**Our ref:** XA/2025/100357/01-L01

**A46 Coventry Junction (Walsgrave) – Development Consent Order Application**

**Examination: Issue Specific Hearing 1 Action**

We have reviewed the Issue Specific Hearing 1 Action Points (dated 8 May 2025) and our comments are provided in the table appended to this letter.

#### **Figure 2.4 Environmental Masterplan**

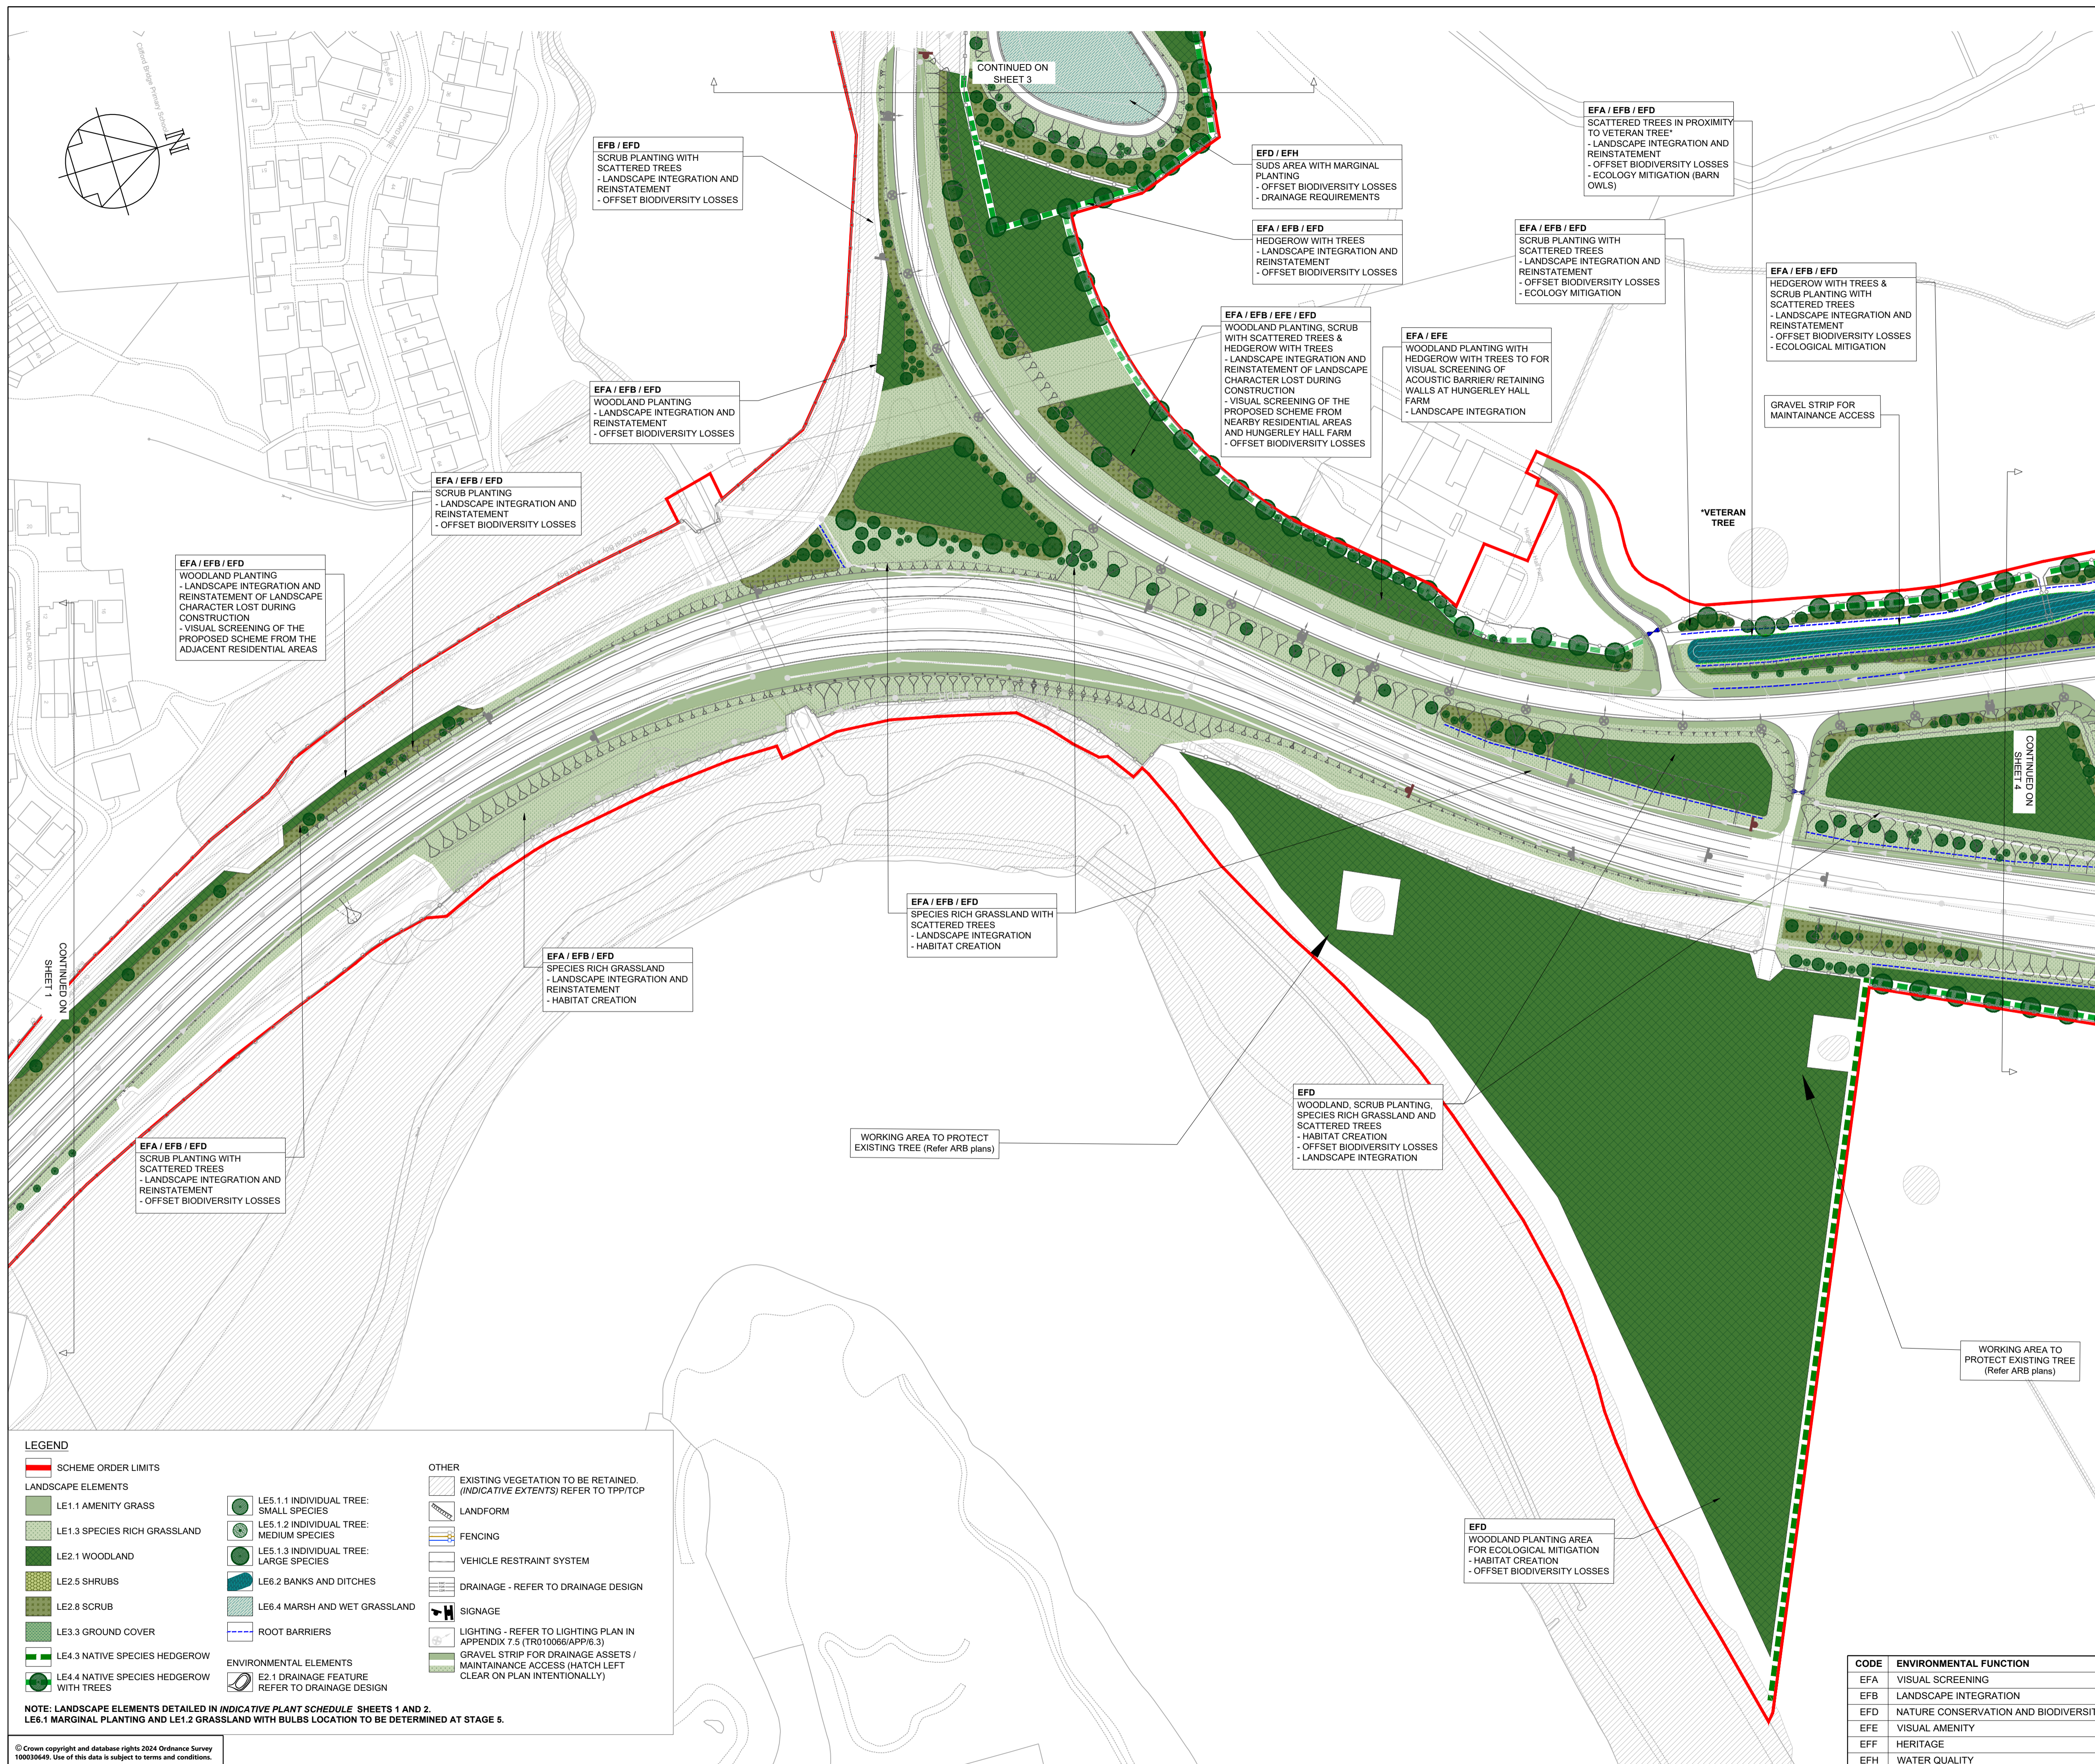
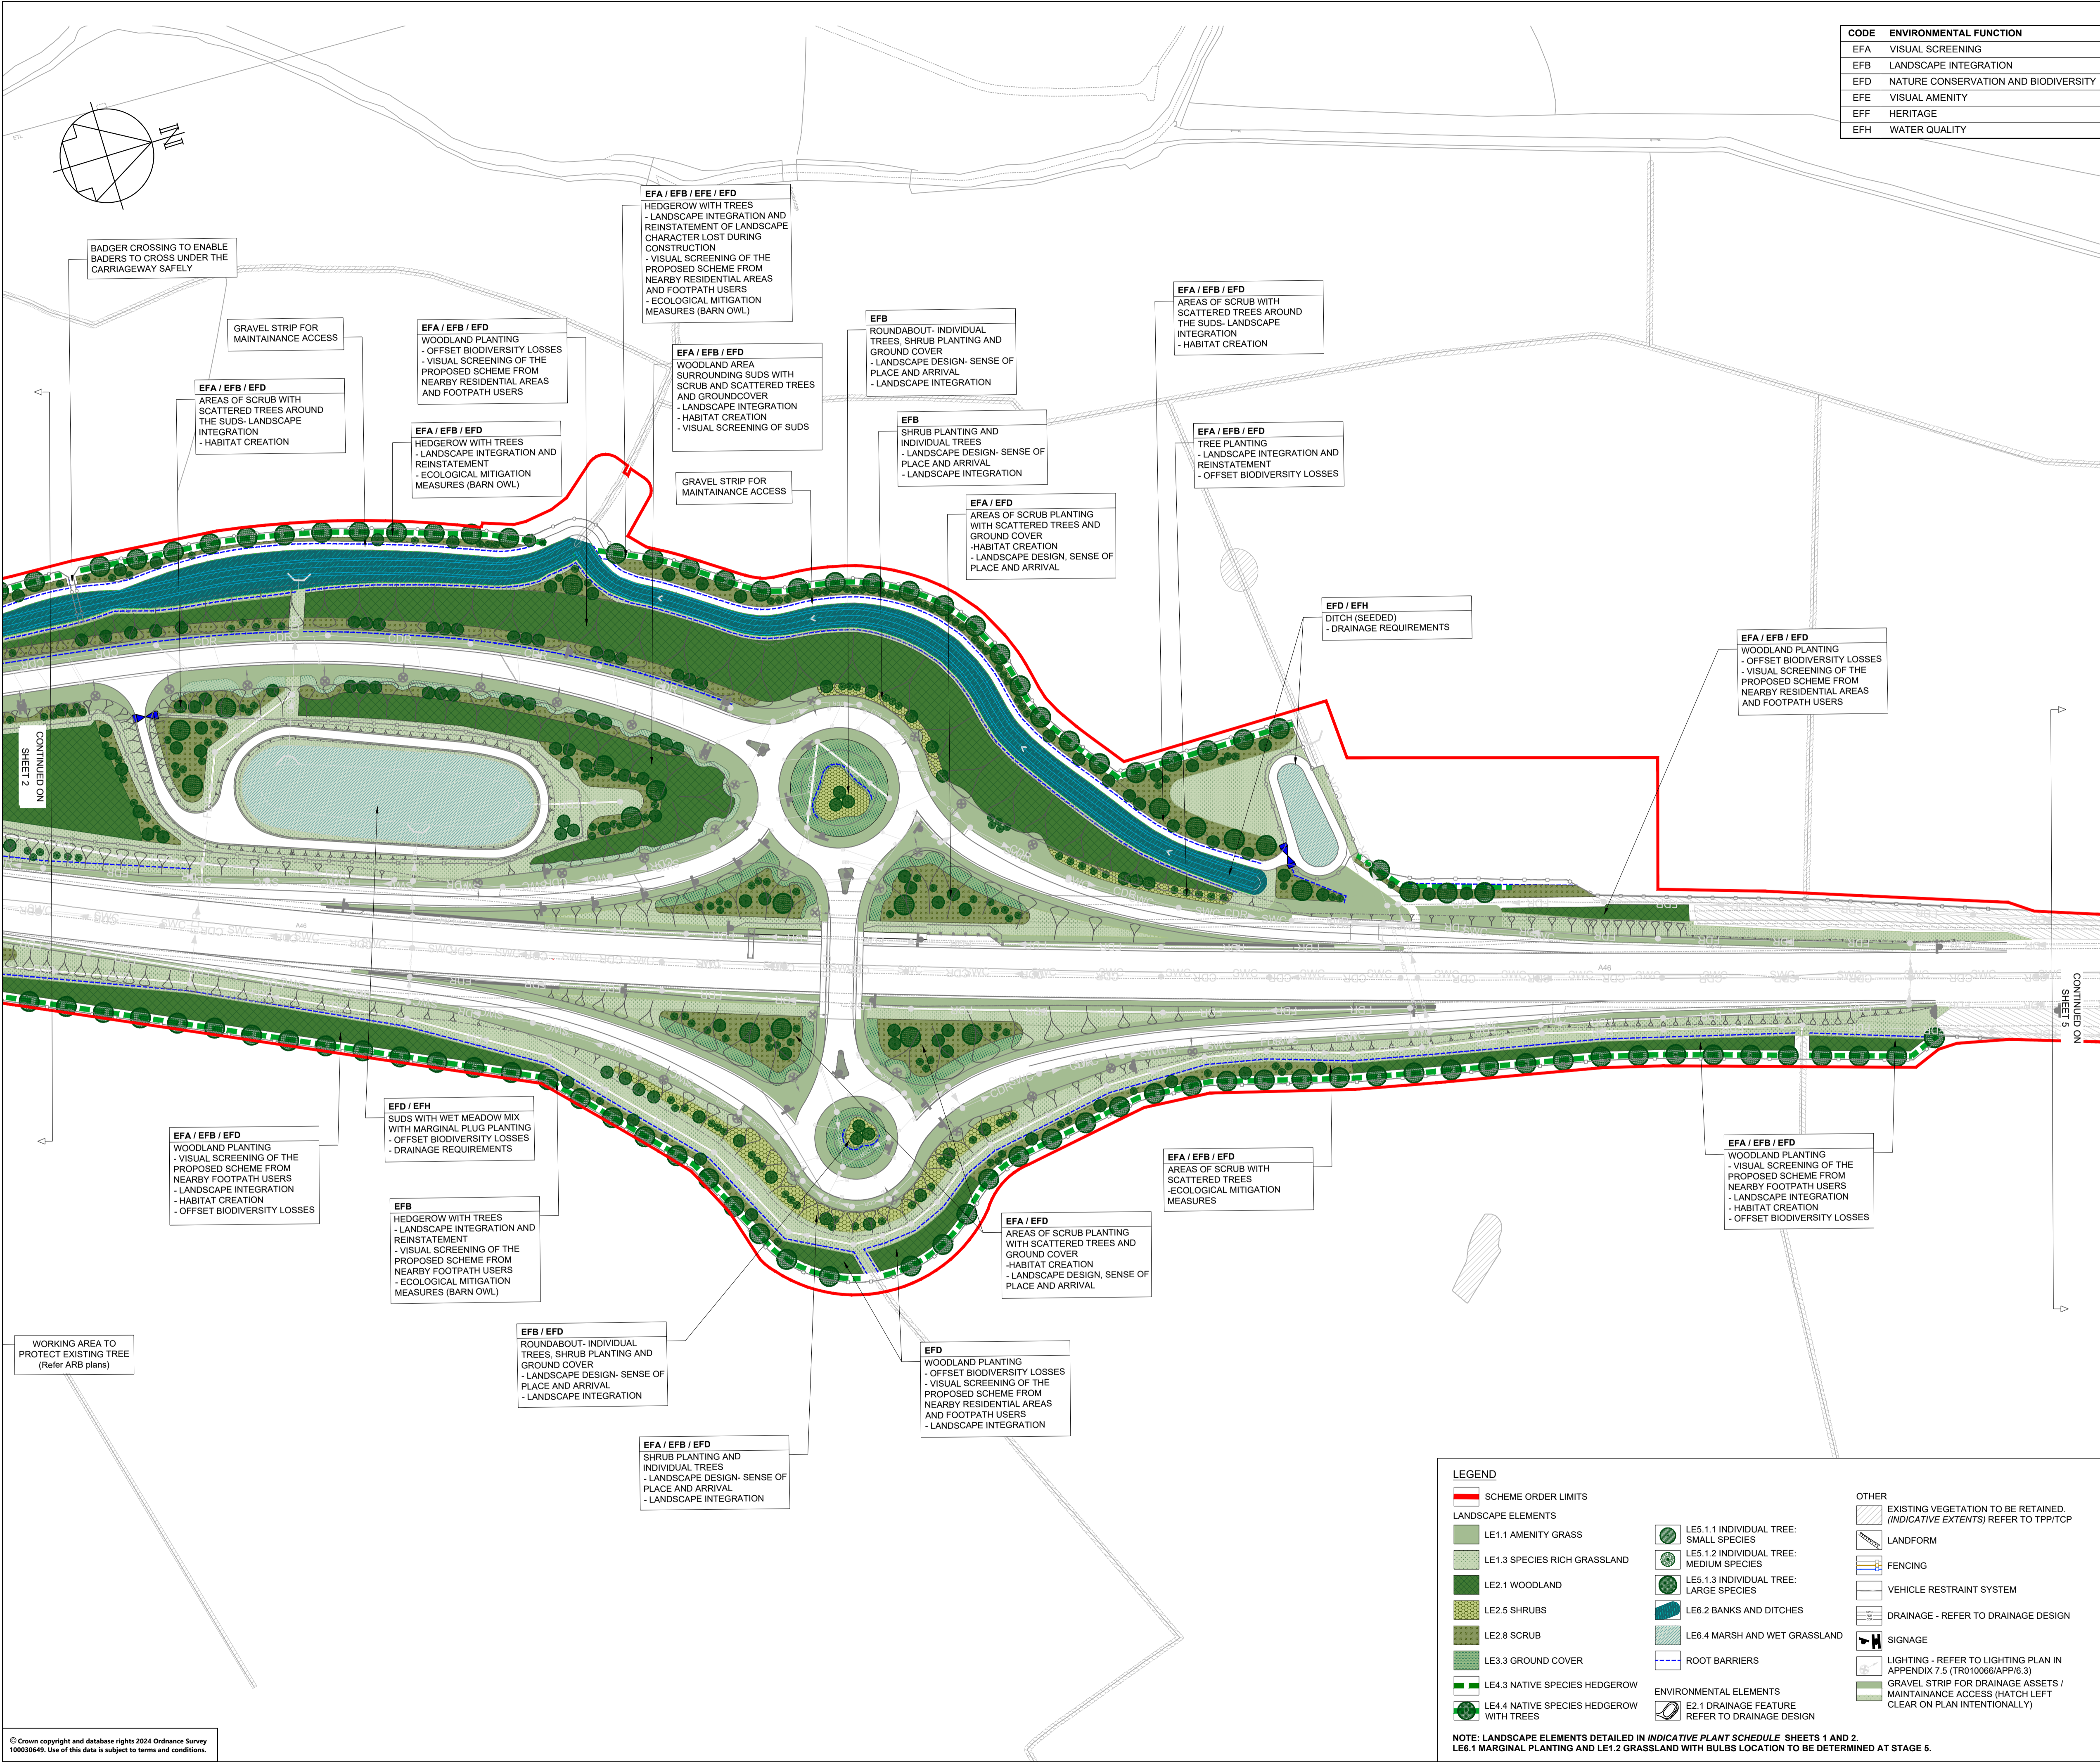
| No | ACTION  | RESPONSE   |
|----|---|--|
|    | What is the Environment Agency's position on the Applicant's proposals to protect and enhance watercourses and the development of new habitats in proposed detention basin? | <p>The Environment Agency (EA) approves of the proposed measures outlined in Figure 2.4, to plant scrub, hedgerows and woodland around the new detention basin, to improve connectivity between the waterbody and the surrounding landscape. We also approve of the native seed and plug mixes chosen to enhance the basin (LE6.4, page 12) and to enhance the riparian edges of the watercourses (LE6.2, page 12). However, we would also recommend adding rushes (e.g. <i>Juncus</i> sp.) to the species lists.</p> <p>In addition, further enhancements measures could be considered to make the detention basin and watercourses more attractive to wildlife by providing habitat variety if possible and practicable.</p> |
|    | Can the Environment Agency provide examples for the suitable and practicable enhancement for the watercourses and detention basin?  | <p>As a regulator, it would be inappropriate for us to outline exactly how the applicant should enhance any habitat on the site; however, we can provide the following examples:</p> <ul style="list-style-type: none"> <li>• The base could be designed with gently sloping earthworks that mimic naturalistic edges, which provide a variety of water depths. Planting will depend on how often the detention basin is expected to be wet throughout the year.</li> <li>• Temporarily wet areas such as at the top of slopes could be sown with wet-grassland species mixes.</li> <li>• Marshy/waterlogged areas such as near the outlet could be planted with emergent aquatic species.</li> </ul>                          |

|    |  | <ul style="list-style-type: none"> <li>• Flatter areas like the base could be planted with marginal aquatic species.</li> <li>• All species should mimic plant communities found within local wetland and marshy habitats. Planting would make the basin more appealing to species such as amphibians, invertebrates, birds and bats.</li> </ul> <p>Enhancement options for watercourses include the removal of physical modifications/artificial banks, the management of invasive non-native species and the retrofitting of mammal ledges to bridges/culverts.</p> |
